65 SADLER ROAD  
(PART OF THE PILOT TRAVEL C-STORE)  
DUNN, NC 28334

# Reviewed for Fire Code Compliance

<p>PROJECT NO. FSDN_2509</p>																																																																																																																																																																												
<p>SHEET TITLE: BUILDING CODE SUMMARY, COVER SHEET &amp; KEY PLAN</p>																																																																																																																																																																												
<p>SHEET NUMBER: CS1</p>

SHEET NUMBER:
A1.2

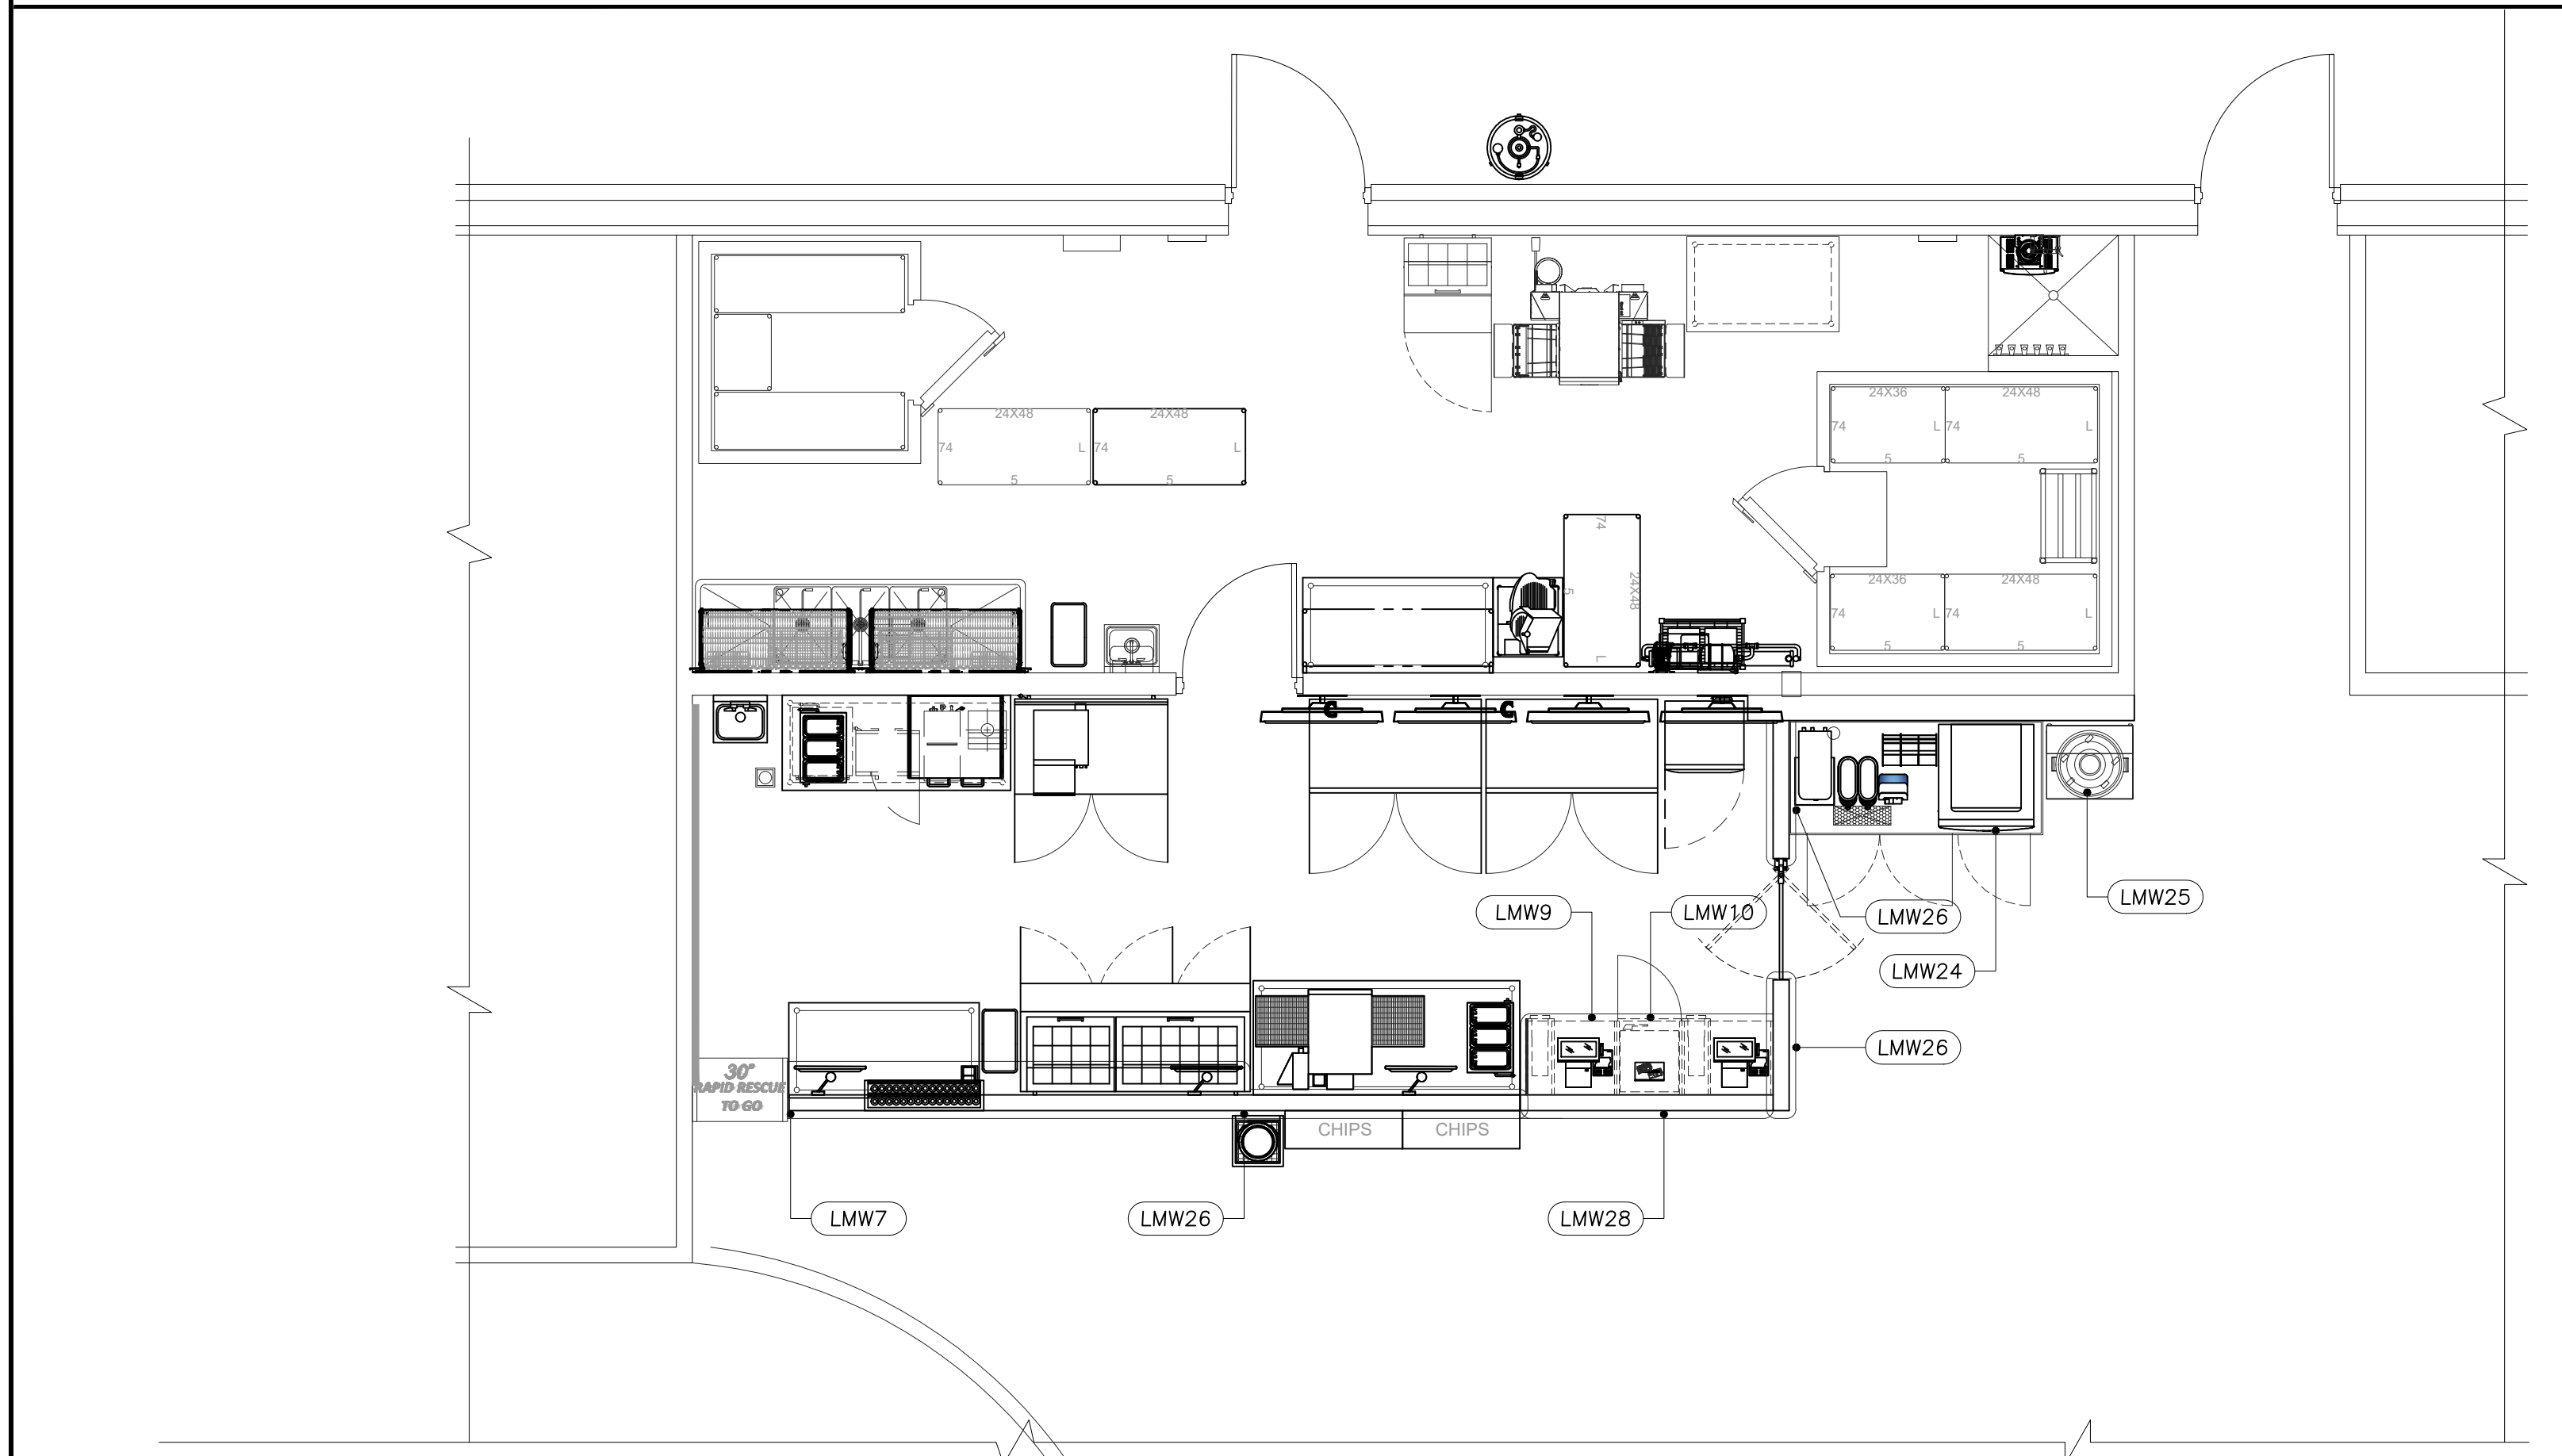
Fryer will require a class K fire extinguisher within 30 feet
